Application No: EP/57/20/HH
Site Address: 32 Vermont Drive East Preston West Sussex BN16 1LA
Description of works: Loft conversion with side dormer and hip to gable extension to rear.

Thank you for your internet representation made on 15th June 2020 which has been recorded as no objection with the comments as follows:

Existing front elevation (1:100)

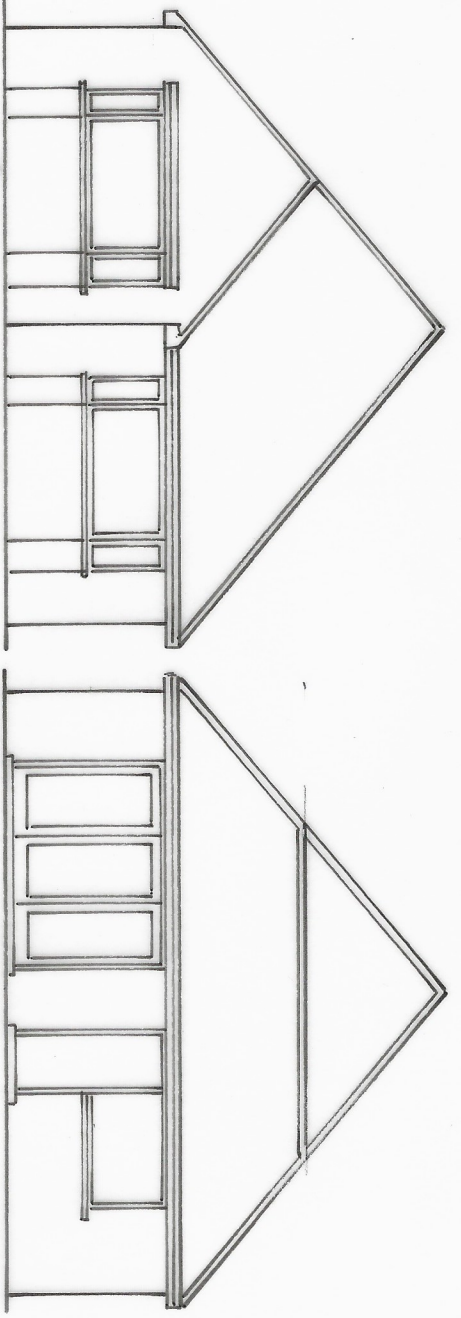
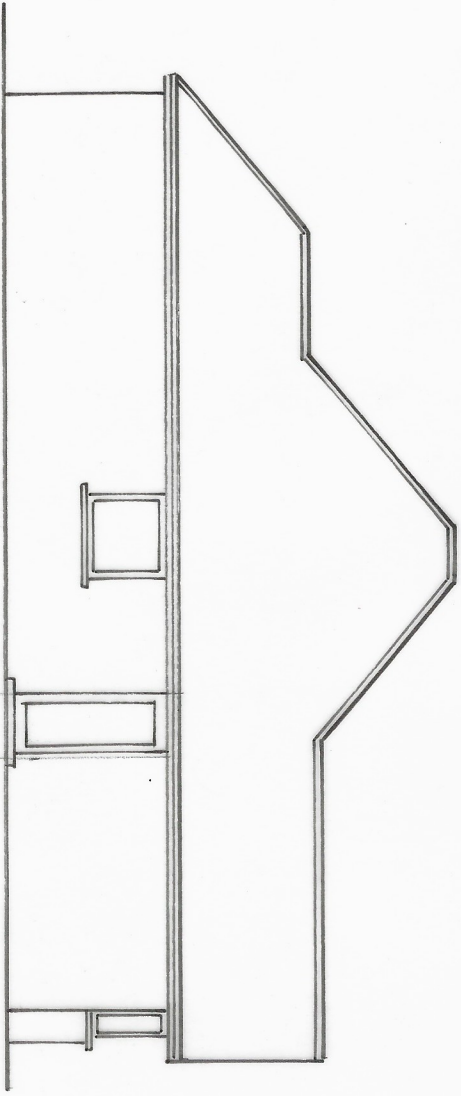
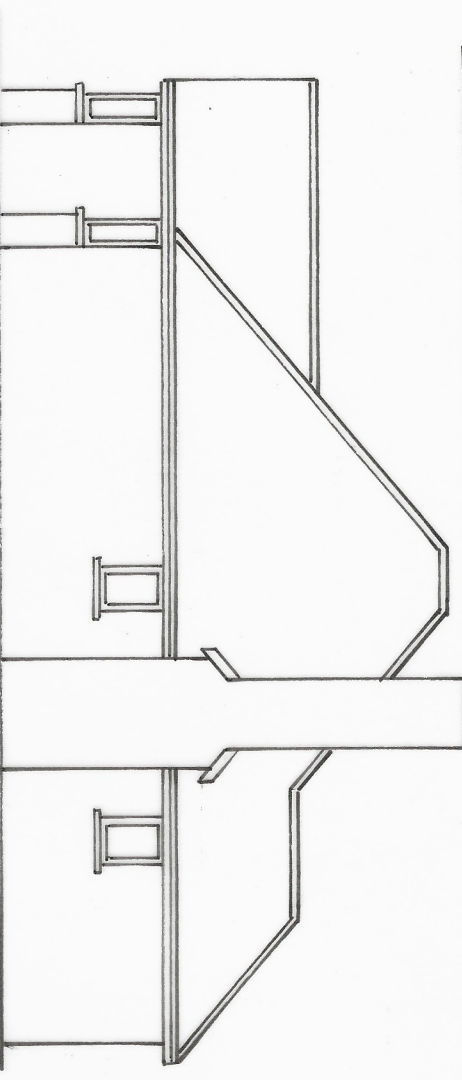
before I can decide about this application there seem to be a few questions about the drawings. I cannot relate the existing elevation plans to the property as it currently shows windows which are not there. The application form is impossible to read in the way it has been uploaded so it is not clear what materials and glazing would be used. The location plan is confusing as it uses a very out of date plan and does not reflect the current properties in the nookery.
